**SUBMISSION OF CONCRUSH PTY LTD ACN 097 606 543 BY WAY OF OBJECTION
TO A PROJECT APPLICATION UNDER PART 3A OF THE ENVIRONMENTAL
PLANNING & ASSESSMENT ACT NUMBER 08_0079 OF LAKE MACQUARIE CITY
COUNCIL TITLED "CIVILAKE CONSTRUCTION AND GREEN WASTE RECYCLING
FACILITY - TERALBA"**

Director General
Department of Planning
GPO Box 39
SYDNEY 2001

Dated: 30 September 2010

APPENDIX F – Impact of Loss of Flood Storage

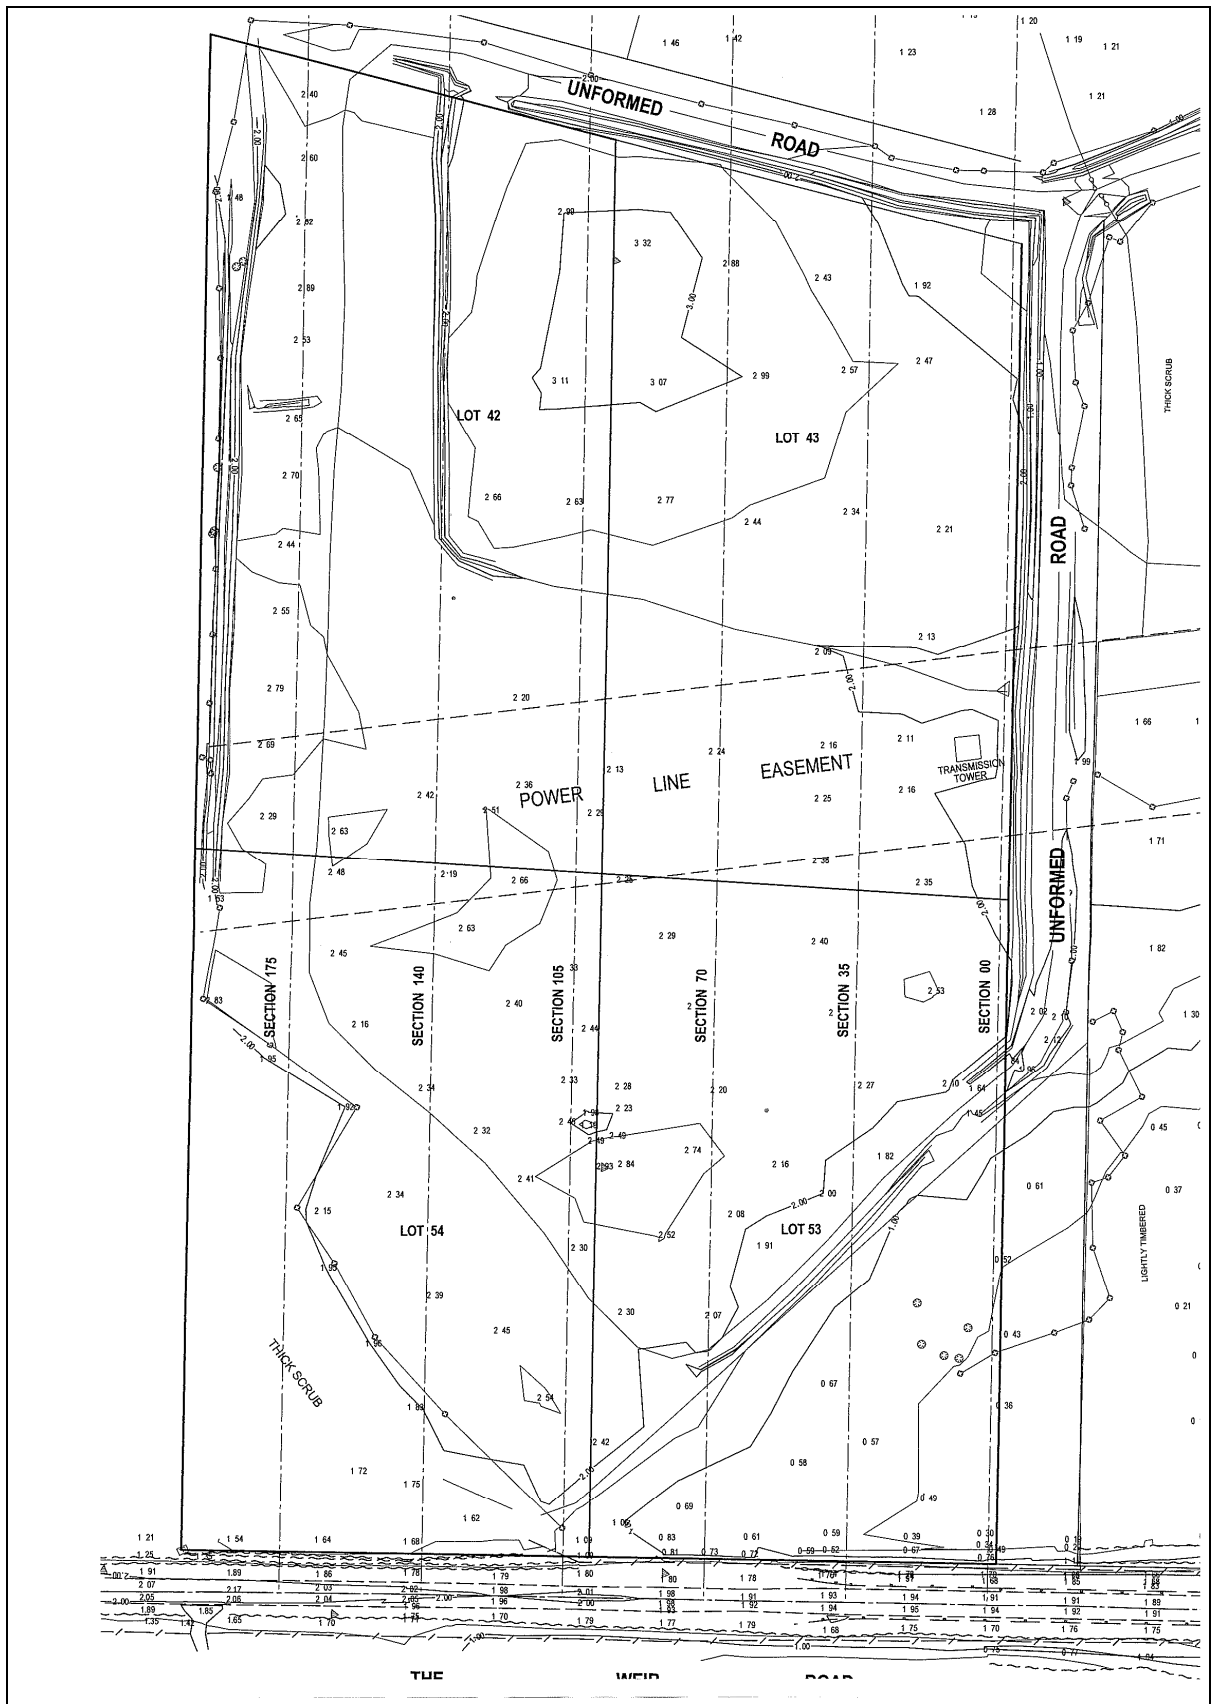
- 2.1 As exhibited the flood study forming part of the EA did not contain Appendices E - HEC-RAS Output Data 100 year ARI Event with Climate Change Considered and F - Impact of Loss of Flood Storage.

The Objector is unable to consider properly the adequacy of the flood study in the circumstances that Appendices E and F have not been part of the exhibition of the proposal.

2.5.4 Does not contain Appendix F which, as referenced by section 9 of the Flood Report, contains calculation of that volumetric analysis. A detailed and reasonable assessment of that volumetric analysis accordingly is unable to be carried out.
